**REQUEST FOR SEARS - ARDEX WAREHOUSE AND MANUFACTURING FACILITY- 657-769
MAMRE ROAD - KEMPS CREEK**

Response to SEARs: SSD-25725029 ARDEX Warehouse and Manufacturing Facility at 657-769 Mamre Road, Kemps Creek

**Comments for Secretary Environmental Assessment Requirements (SEARS)
request for the ARDEX Warehouse and Manufacturing Facility at No's 657-769
Mamre Road, Kemps Creek**

1 EAST ELEVATION
1:300 DA 200

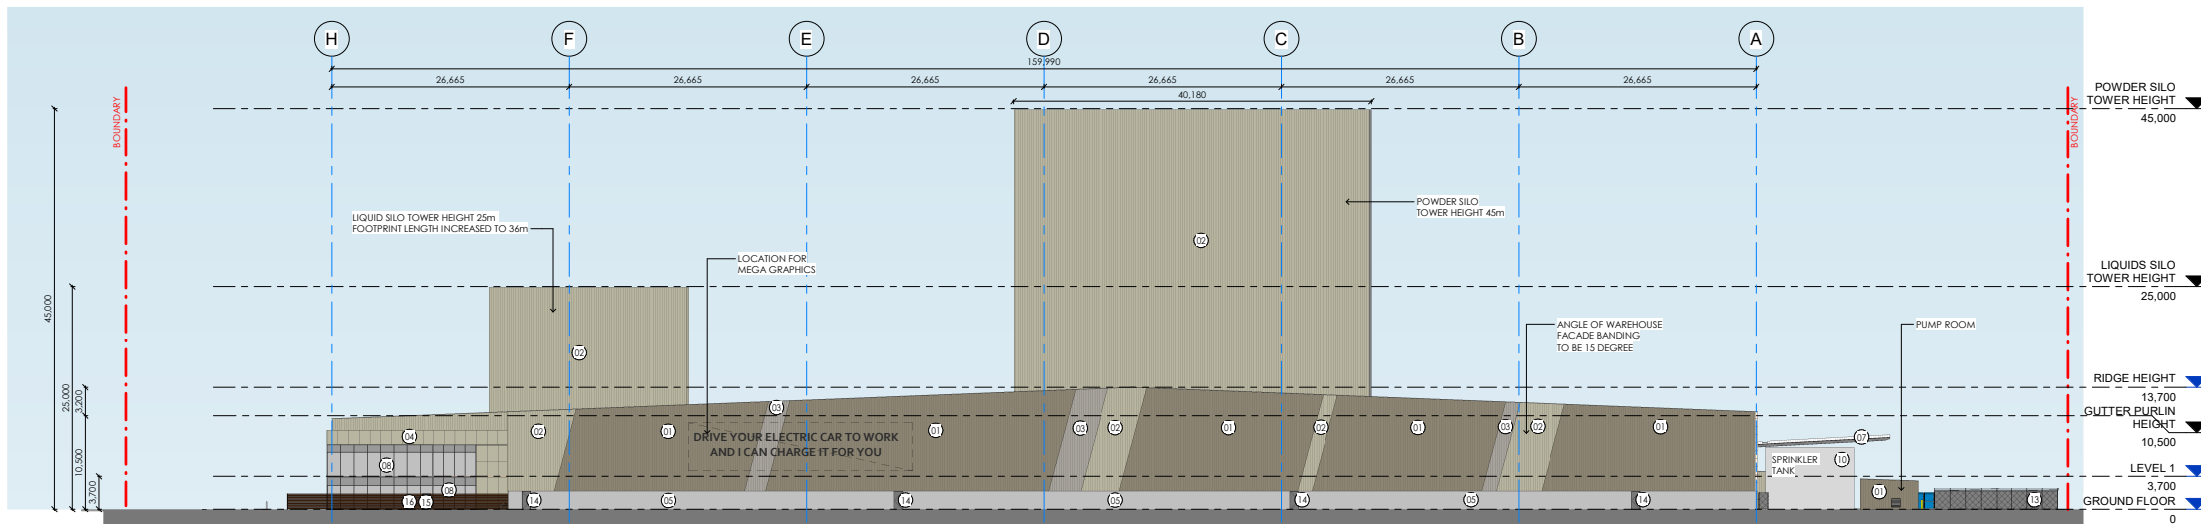
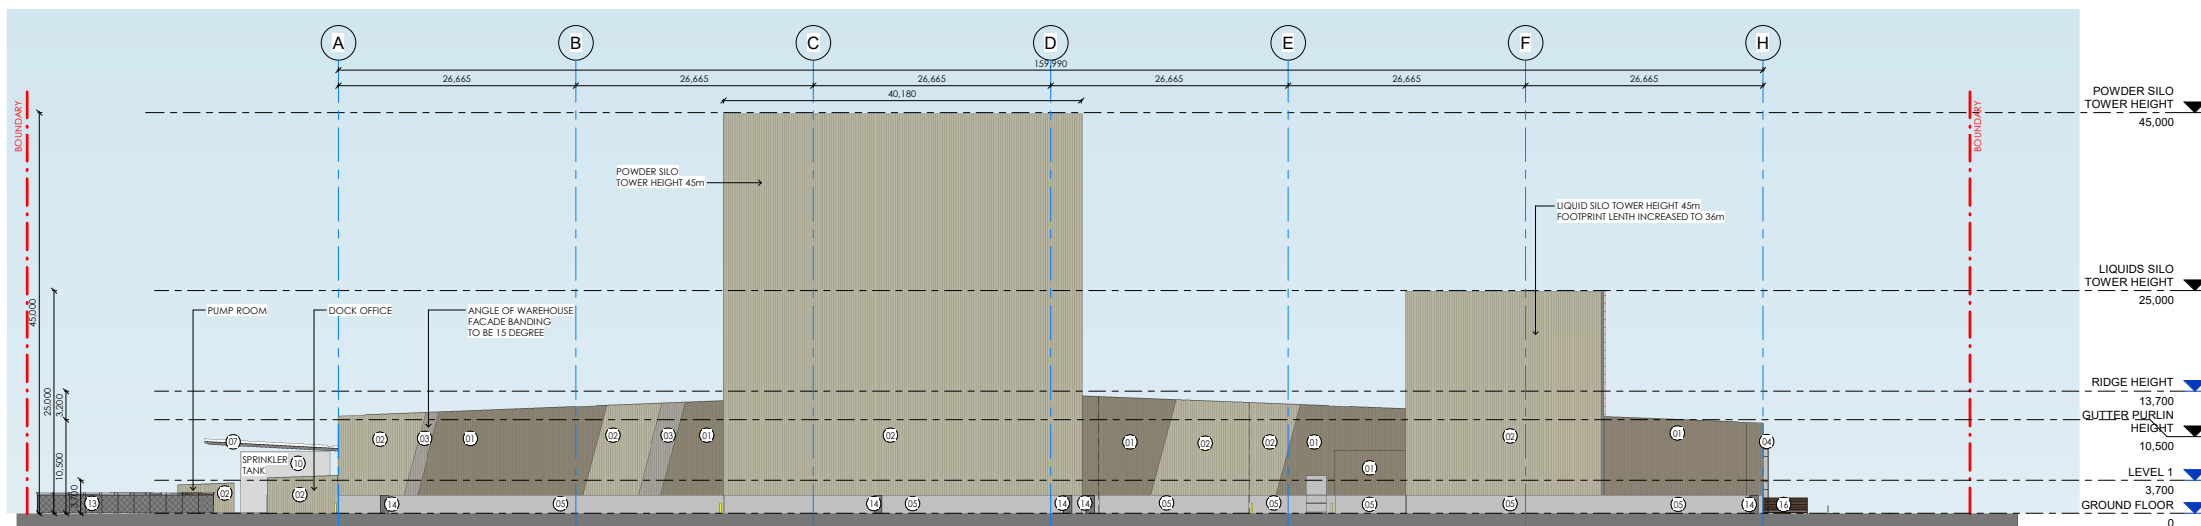
- The proposed building height exceeds the development form envisaged within the Western Sydney Employment Area, or more specifically the Mamre Road Precinct. The elevation drawing suggests a 45m maximum building height with a secondary silo tower at 25m. While the precinct has a site specific DCP approved, the proposed Draft DCP for the entire Mamre Road Precinct establishes maximum building height of 20m where not adjoining rural – residential zoned land. While allowances for taller elements is made in the draft DCP, this is based on specific planning justification and consideration of solar impact and a visual impact analysis. It is also understood that additional height allowance is to acknowledge the different operating requirements of vertical warehousing and allow for a level of flexibility in design to address operational needs however operational needs should not be at the expense of contextual integration. Where suitable and contextual integration cannot be demonstrated, the key consideration under the EP&A Act 1979 concerning suitability of the site for the development cannot be satisfied.

- Any consideration of height beyond 20m must be informed by a detailed visual impact assessment. Due to the potential visual impact that the

proposed development will have on the residences of Twin Creeks, as well as the scale and relationship of the proposal to compliant built outcomes in the WSEA Precinct, the proposal is not currently considered appropriate. If pursued, the application will need to clearly outline how the development mitigates the visual impact on Twin Creeks in addition to the surrounding existing and planned landscape.
